Demolition of existing building & construction of 1 No retail unit & 3 No. flats with associated external works & access. This application affects the setting of listed buildings & may affect the character & appearance of the River Road, Littlehampton Conservation Area.

Littlehampton Covered Market 26-28 Surrey Street Littlehampton

Thank you for your internet representation made on 27th April 2020 which has been recorded as '**an objection**' with the comments as follows:

Proposed Plans And Elevations

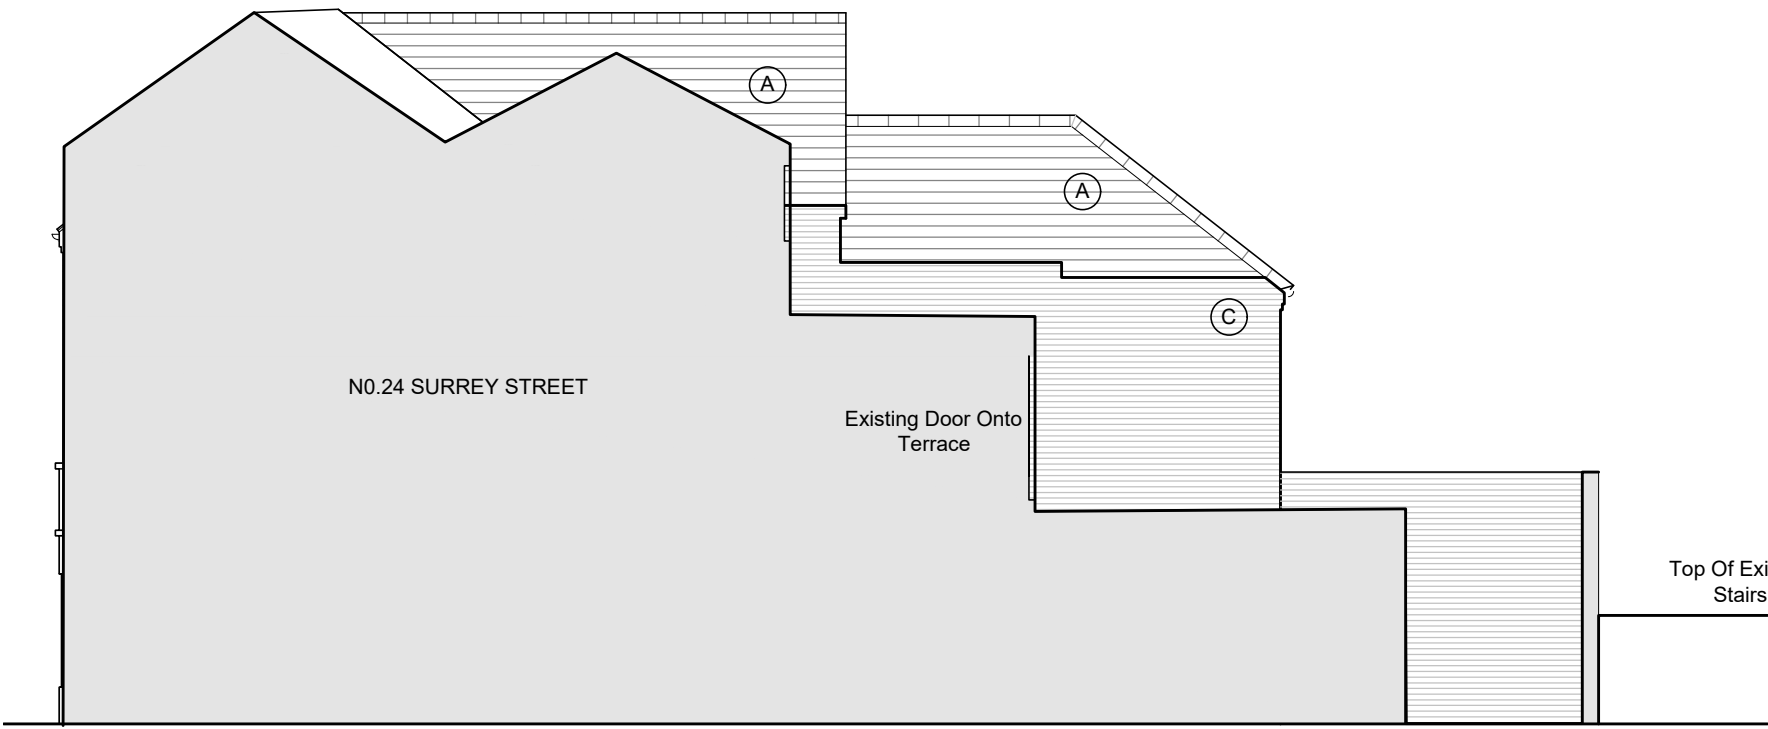
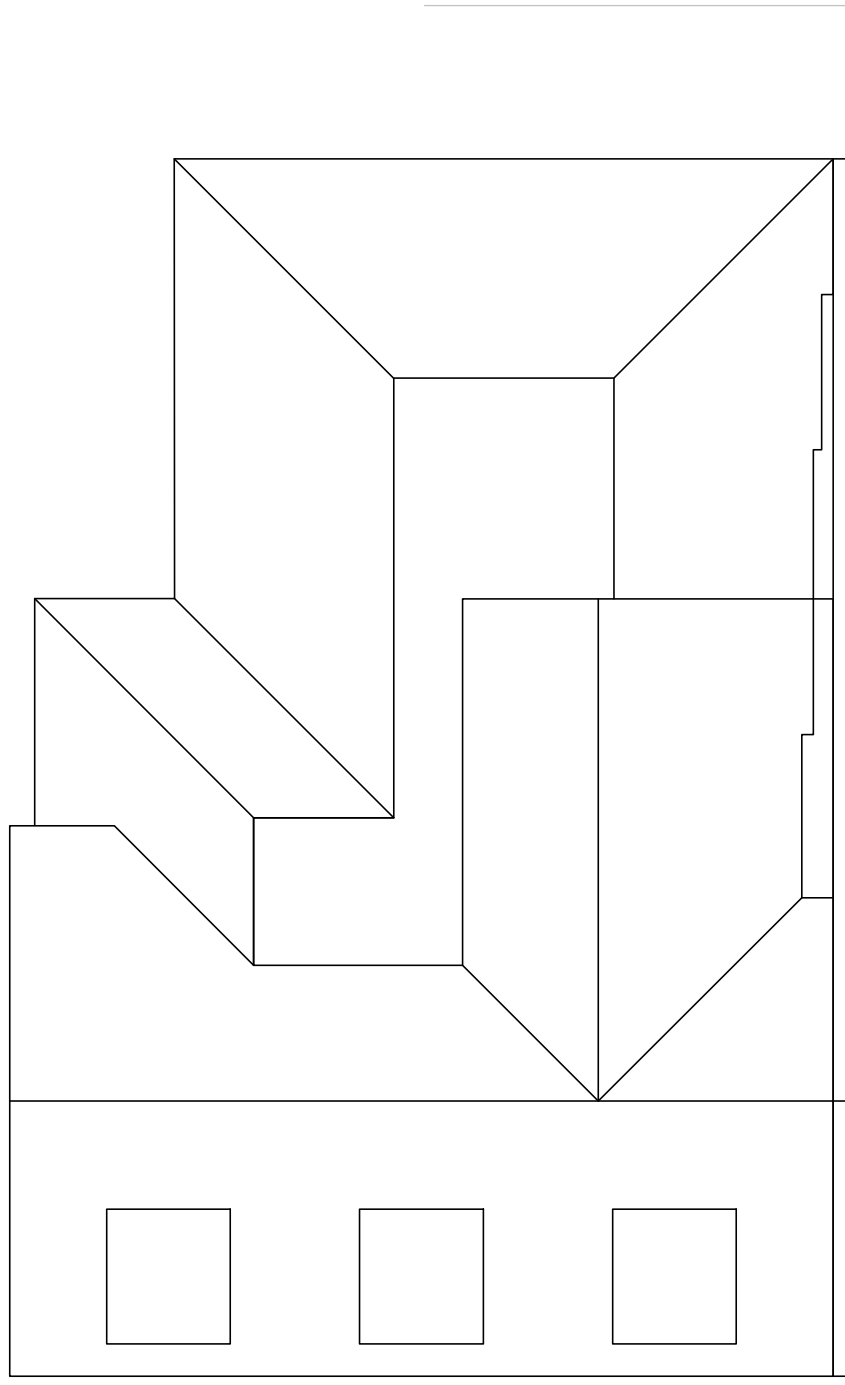
However, the Panel do object to that part of the materials and finishes schedule which refer to "false slate tiles" and "white sash effect windows". Given the location of the building at the entrance to the River Road Conservation Area and the very close proximity of 20-24 Surrey Street, White Hart PH, and Floyd's Corner, all Grade 2 Listed Buildings, then the use of natural slate for the roof and properly formed painted timber vertically sliding sash windows are essential to protecting the setting of these designated heritage assets. It is strongly recommended that the materials schedule be amended accordingly before any planning permission is granted.

Given that the new building will immediately abut a Grade 2 Listed Building then the choice of brick, mortar and indeed brick bond will be important and samples and details need to be the subject of a condition of planning permission. So too should precise details of fenestration (including depth of setback in the walling), eaves and verges. Perhaps fuller details of the proposed shopfront should also be required.

If the schedule of materials and finishes shown on the plans is not satisfactorily amended then it is considered that the proposed development fails to comply with the relevant paragraphs of the NPPF 2019 and policies contained in the Arun District Local Plan 2018 relating to the protection of the setting of designated heritage assets.
